New Request for Advice - EIS - Darlington Public School Redevelopment (SSD-9914)

TAB A – TfNSW Comments – SSD-9914 Darlington Public School Redevelopment

5.0 BICYCLE STORAGE

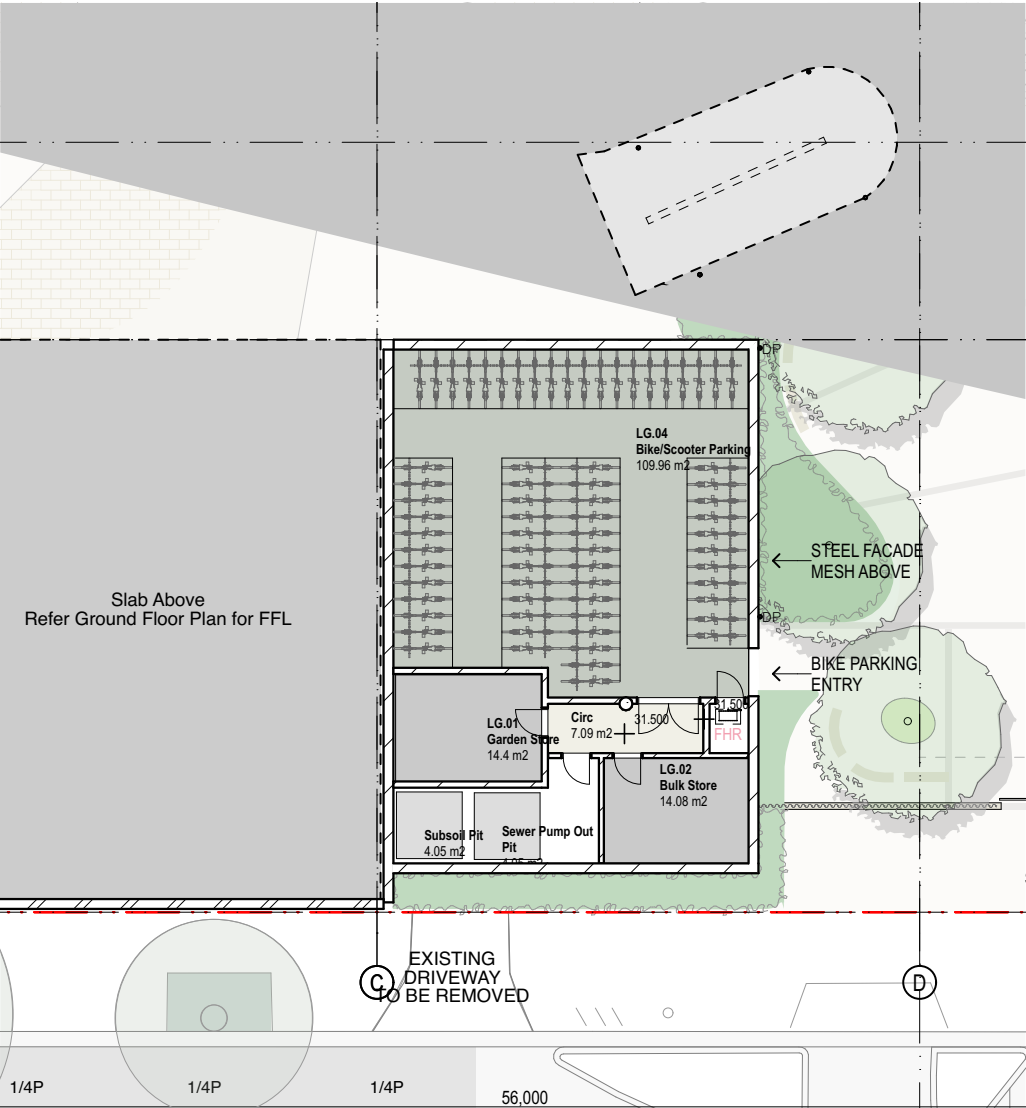
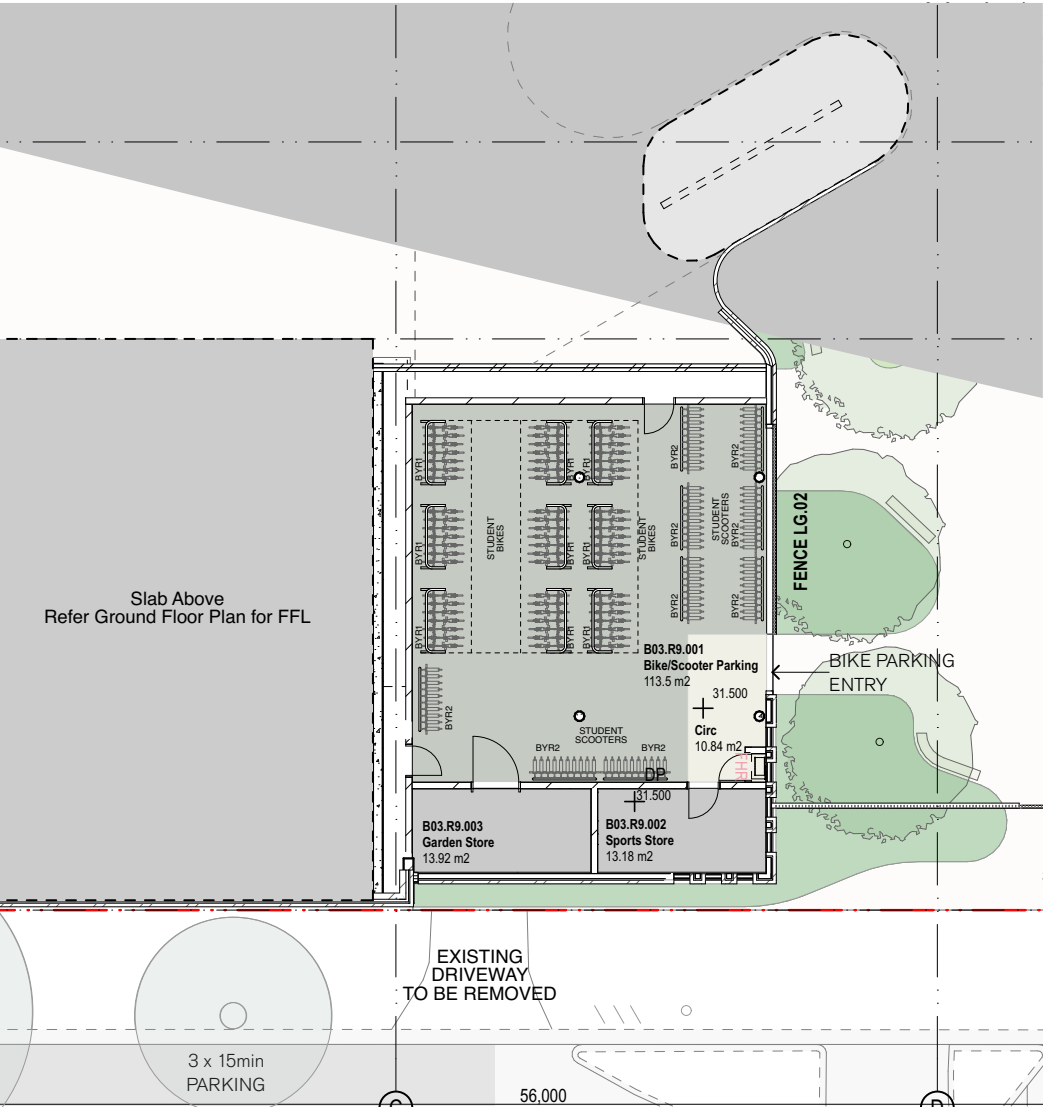
The Transport Impact Assessment (TIA), addresses Active Transport considerations but could be further refined. Off-street bicycle parking requirements applicable to the existing school and proposed redevelopment are referenced, per an Access Survey, however the TIA proposes a lower number of bicycle parking spaces with two accessible bathrooms with shower for staff use. There appears to be no information about the number of lockers to be provided.

There is an opportunity for the redevelopment to promote NSW policies to encourage student and staff mode shift to cycling by providing the maximum number of secure bicycle parking spaces, end of trip facilities and lockers.

It is requested that the Applicant review the needs of active transport users as noted above and if required provide supplementary information as part of the Response to Submissions. The City of Sydney Council DCP 2012 outlines minimum requirements in this regard.
